HCI ENGINEERING

Re: Responses to Conditions of Approval – Dated May 13, 2016
Project: HCI 15-34 Taco Bell at McMahon Marketplace

The following letter addresses the comments from the Official Notification of Decision.

**TACO BELL**  
 UNSER BLVD  
 ALBUQUERQUE, NM 87114

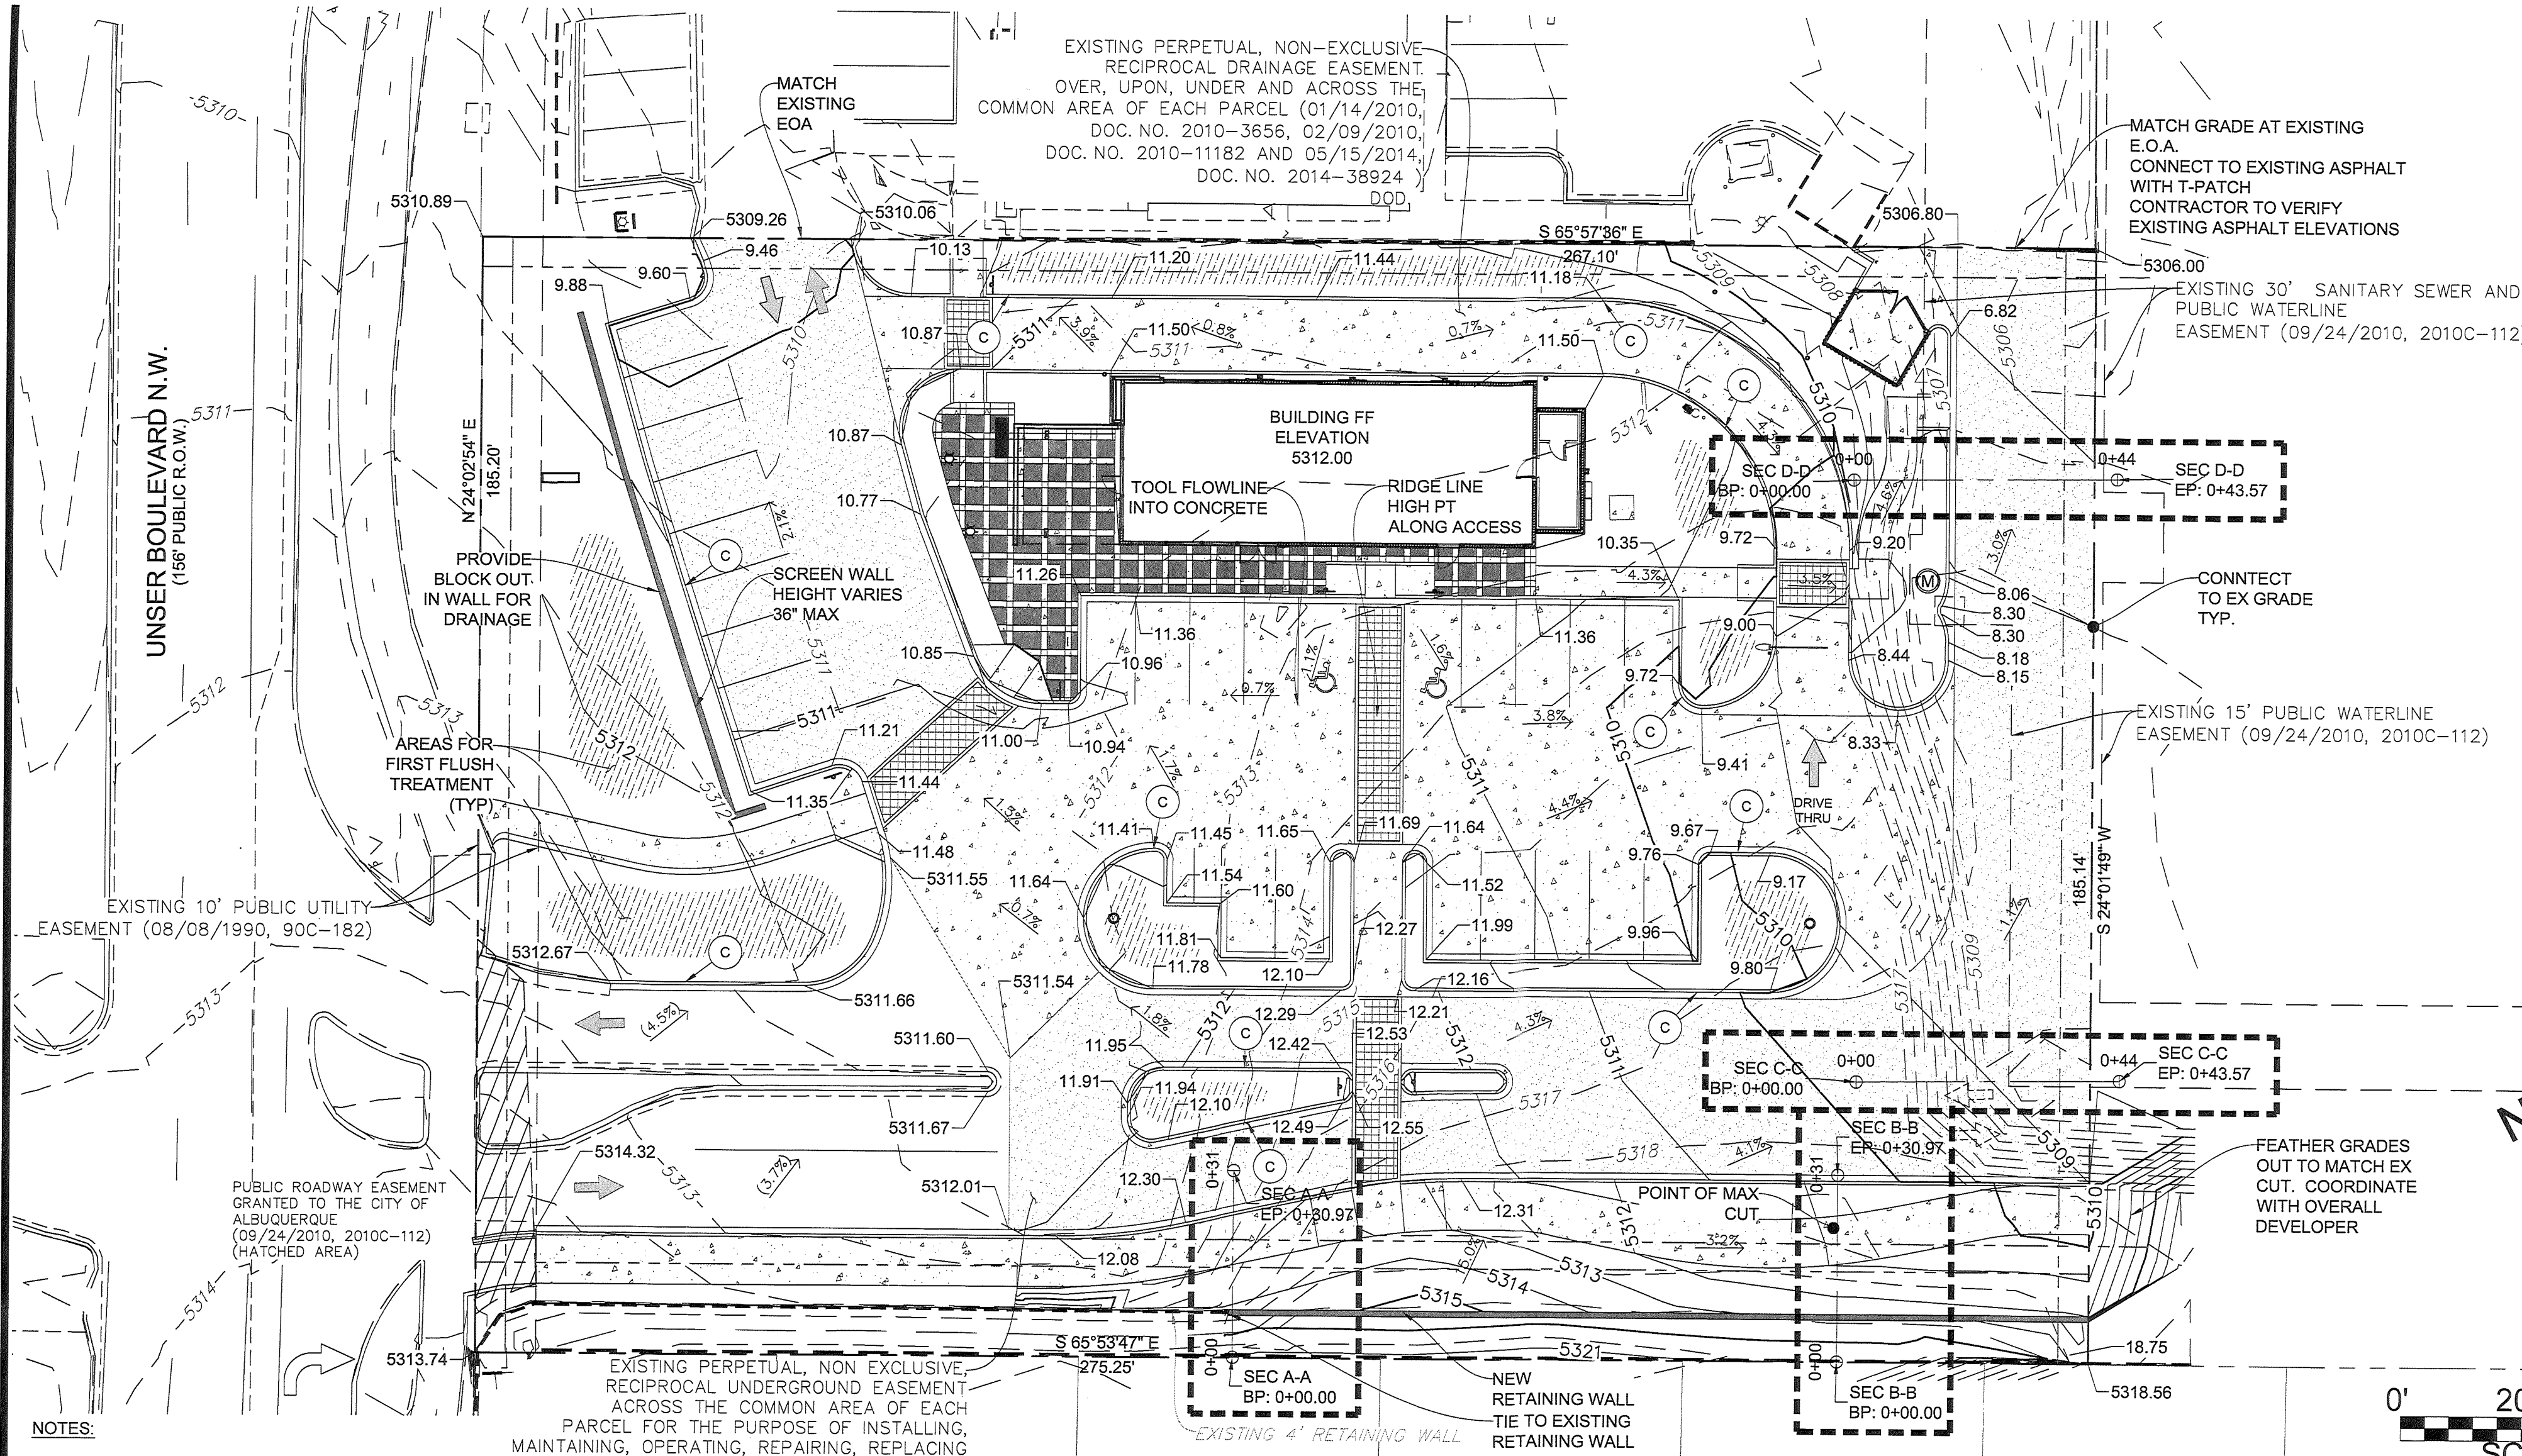
- a. Use a consistent symbol for the existing retaining wall (Sheet C1.0).

- b. The patio area shall be dimensioned and clearly indicated (Sheet C1.0).

- c. Keynote the bench (Sheet C1.0).

- f. Keyed note 1 shall be revised to refer to “Monument Sign”, not “Marquee Sign” (Sheet C1.0).

Response: The symbol has been made consistent.

Response: The patio has been dimensioned and labeled.

Response: The bench has been keynoted.

Response: Keynote 1 has been revised.

**(WEST) FRONT ELEVATION 1/4" = 1'-0" C**

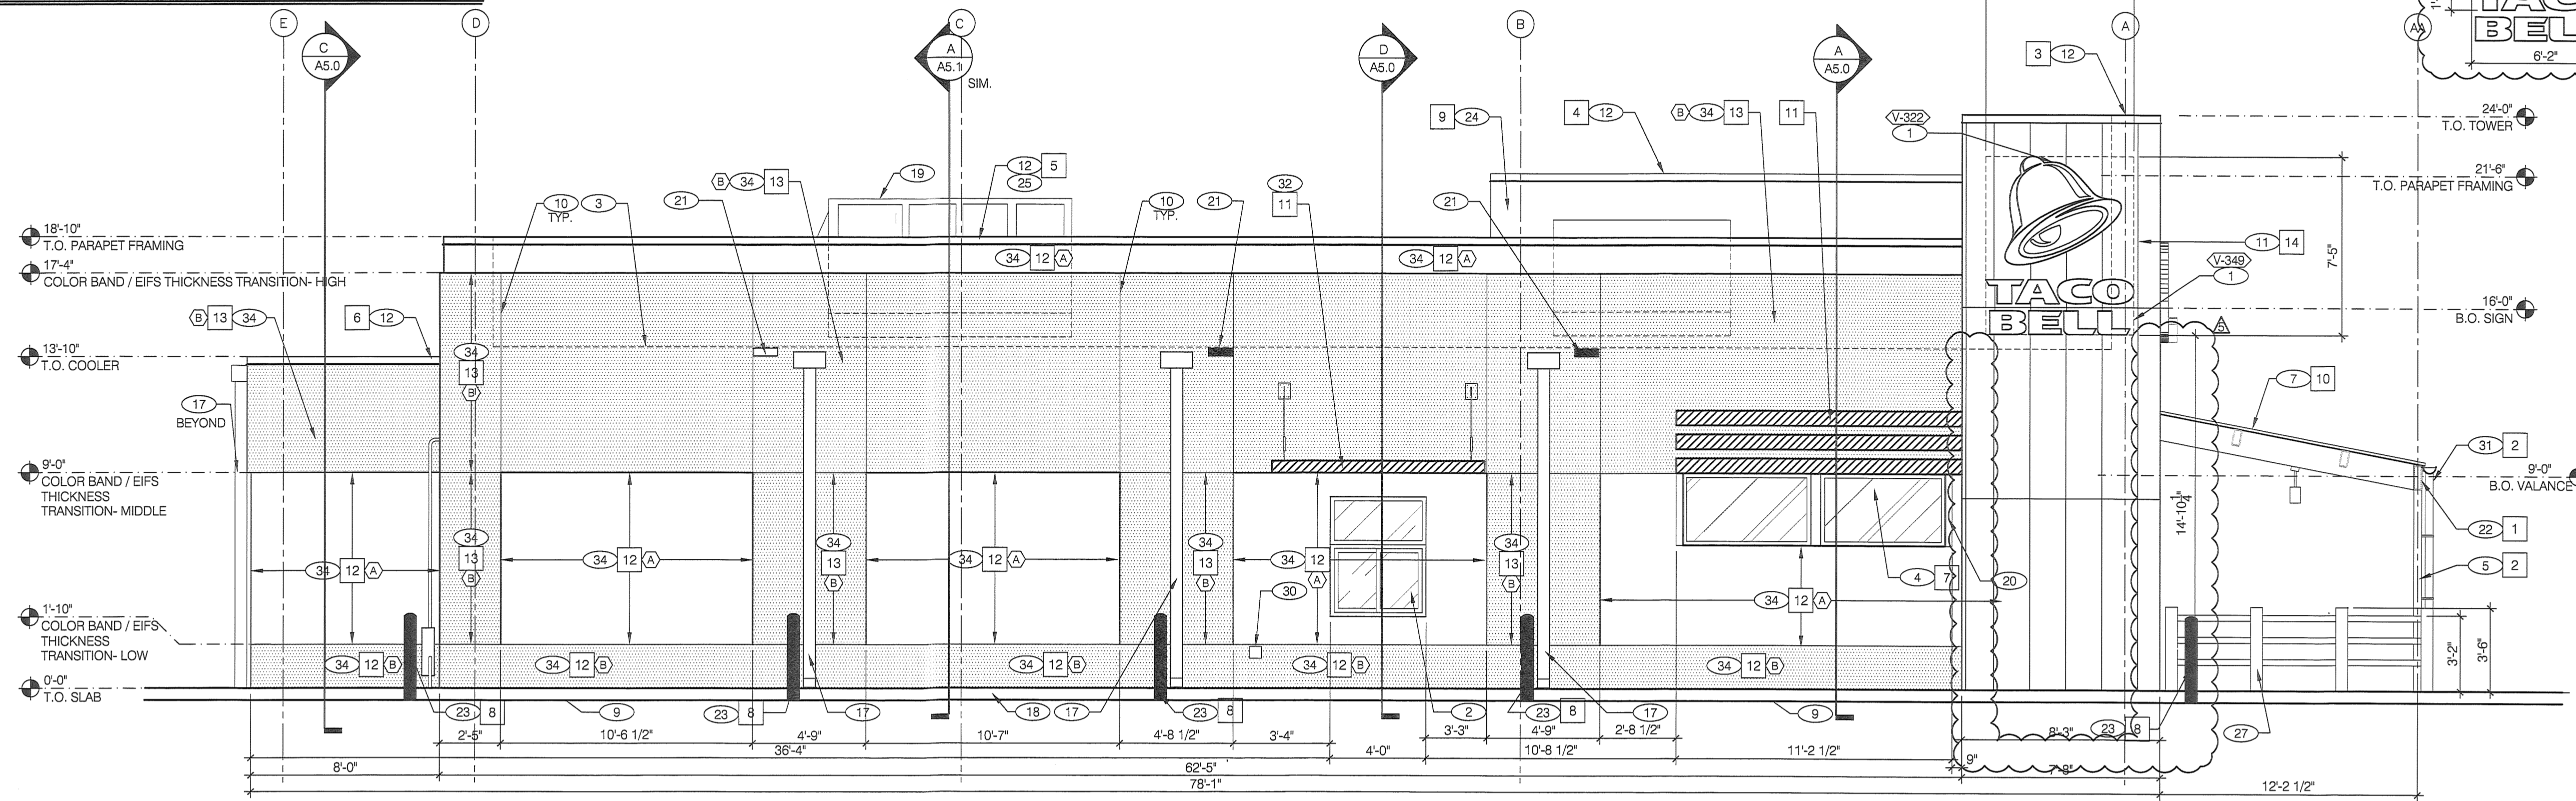
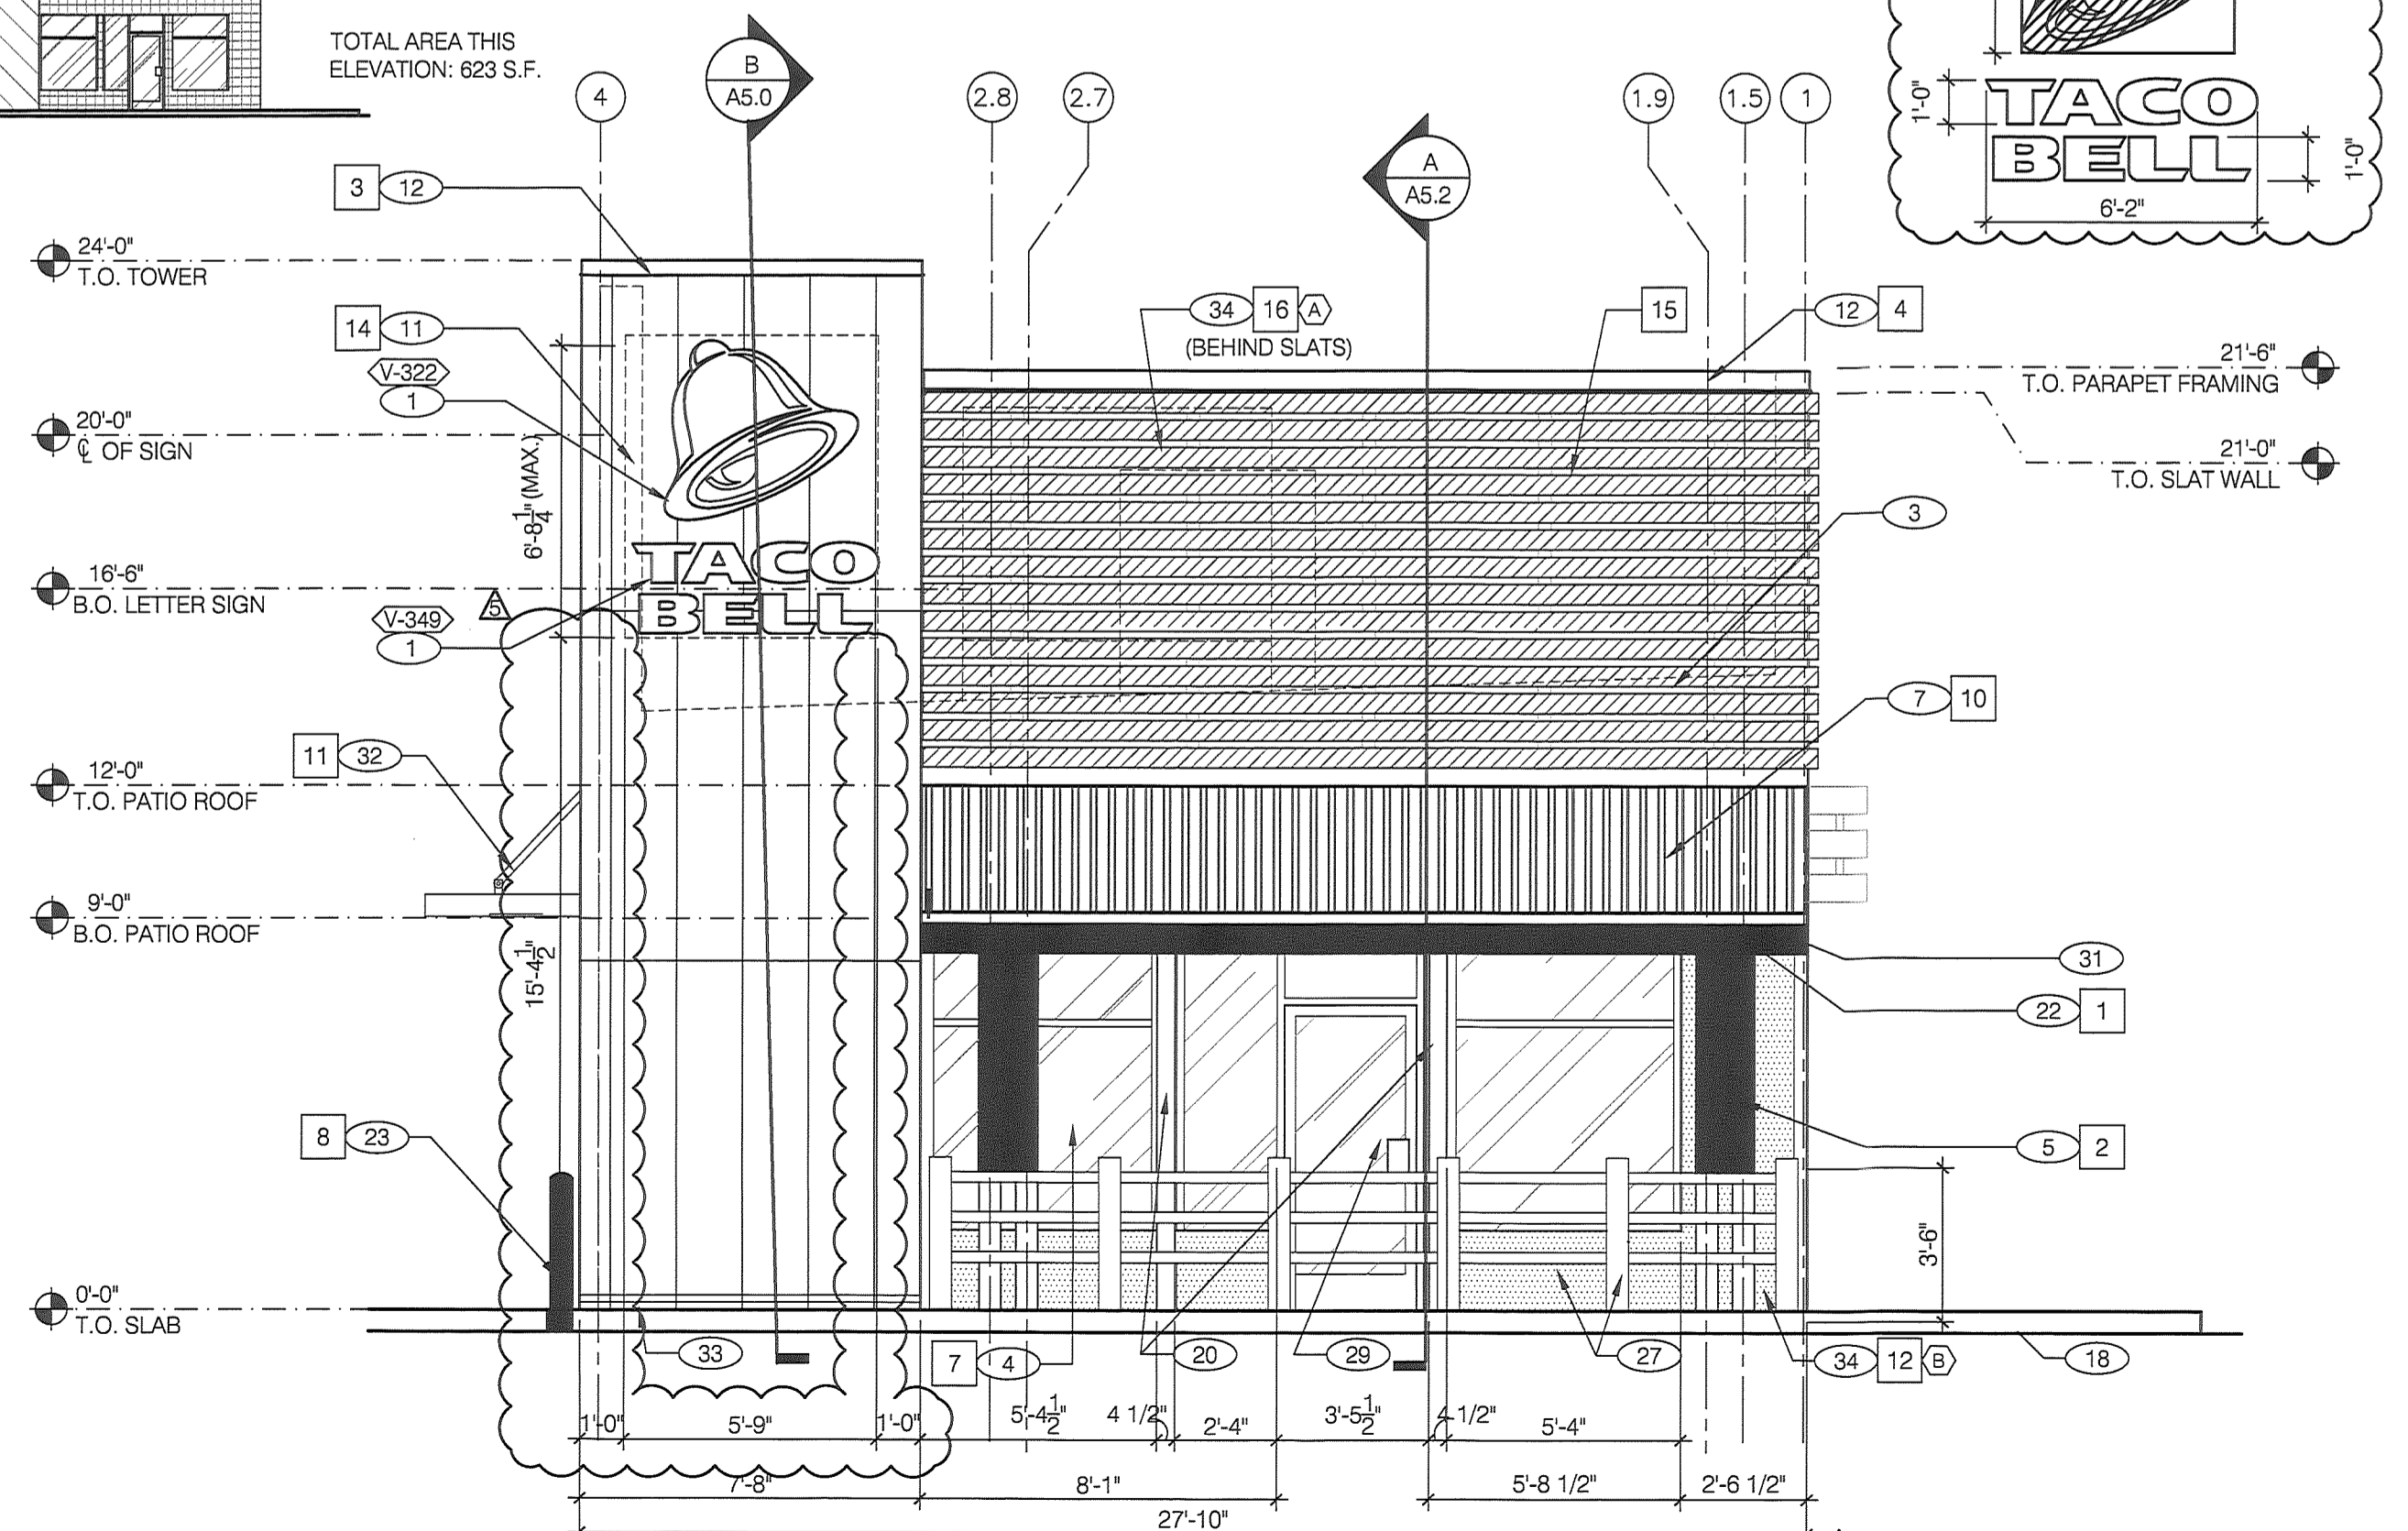
- a. The building mounted signage on the western elevation shall be reduced from 6.8% of façade to comply with the 6% of façade limitation (Standard I.2.a.1).

- g. Label the elevations using directions (Sheets A4.0 and A4.1)

Response: The signage has been reduced.

Response: The elevations have been labeled with directions.
